## Preliminary Site Analysis Report

<b>PSA #:</b>	CA-15-00270	<b>Map #:</b>	21-13-17050-0004
<b>Issue Date:</b>	7/22/2015	<b>Expiration Date:</b>	7/22/2016
<b>Parcel #:</b>	326635	<b>Site address:</b>	3220 VIA KACHESS RD EASTON
<b>Owner:</b>	HERIC, DAVID J & CINDY J 809 9TH AVE S EDMONDS, WA, 98020-3907 daveheric@outlook.com, 425-766-2973	<b>Authorized Agent</b>	ALPINE DESIGN 581 STRANGE RD. ELLENSBURG, 98926 jbt@fairpoint.net, 509-929-1287
<b>Proposed use:</b>	ATTACHED GARAGE

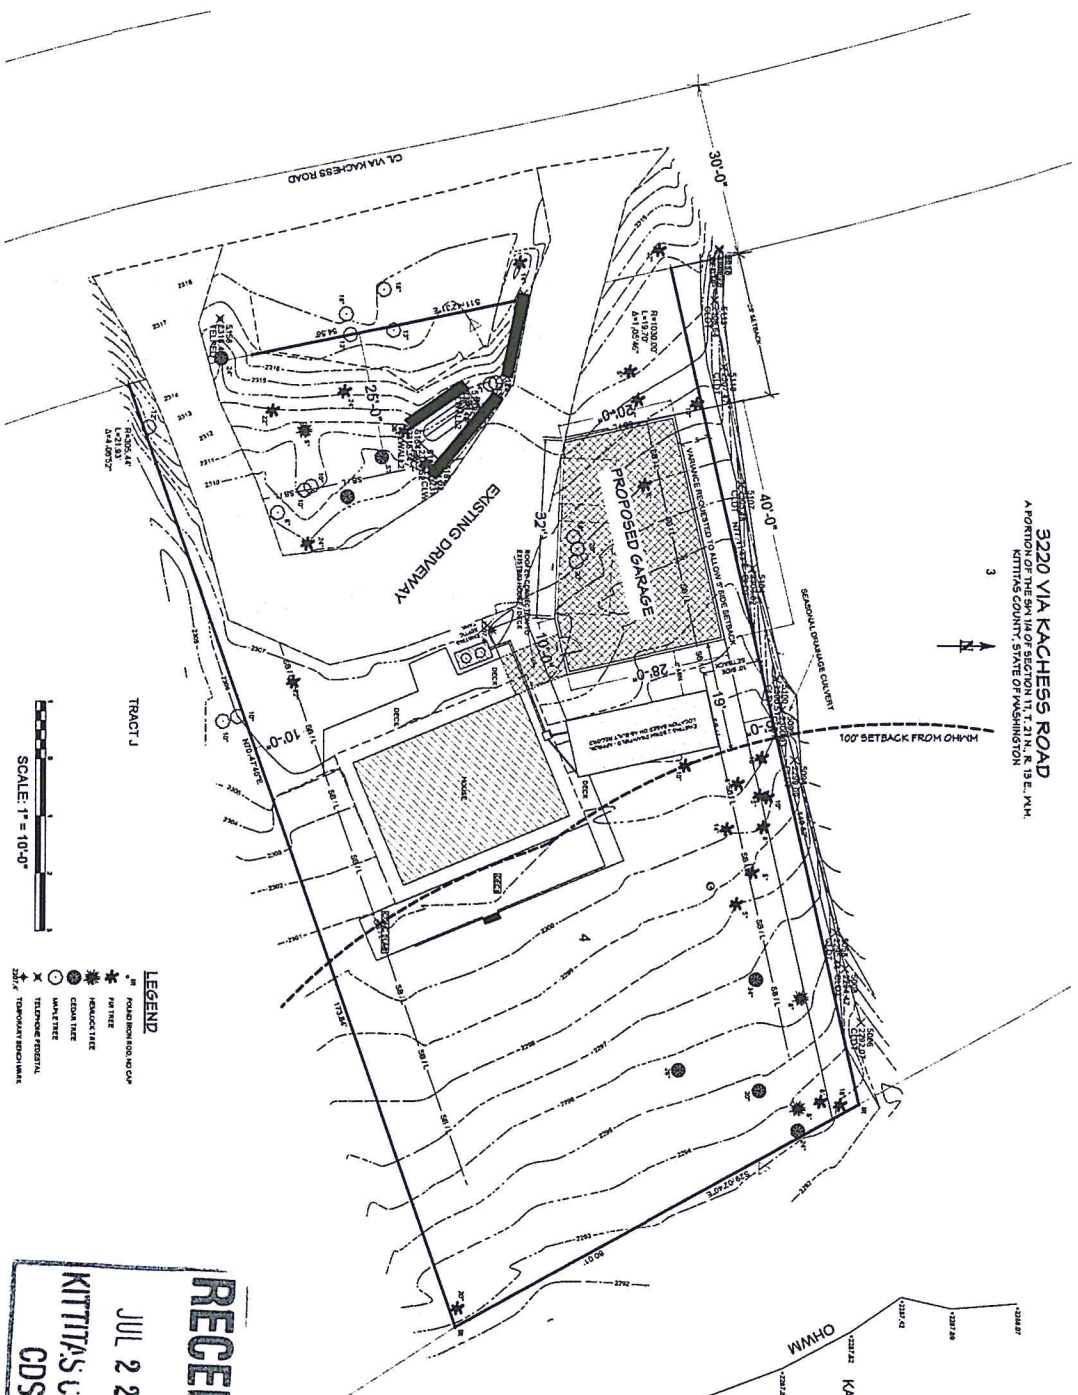
- As discussed in an email with Jim Miller (Alpine Design) on July 1, 2015, a zoning setback variance will be required to be applied for and approved prior to issuance of a building permit because the side setback is not met according to the site plan provided. Zoning variances shall be in conformance and meet all criteria as outlined in KCC 17.84.

- *According to our GIS data, this landslide traveled through the middle of the property. From the site plan provided it appears the landslide would have traveled through the location of the existing house. A Geotechnical report is not required, but CDS Planning advises the applicant to obtain a geotechnical review of the site and the soil stability due to the fact that there has been a recorded landslide on the subject property.*
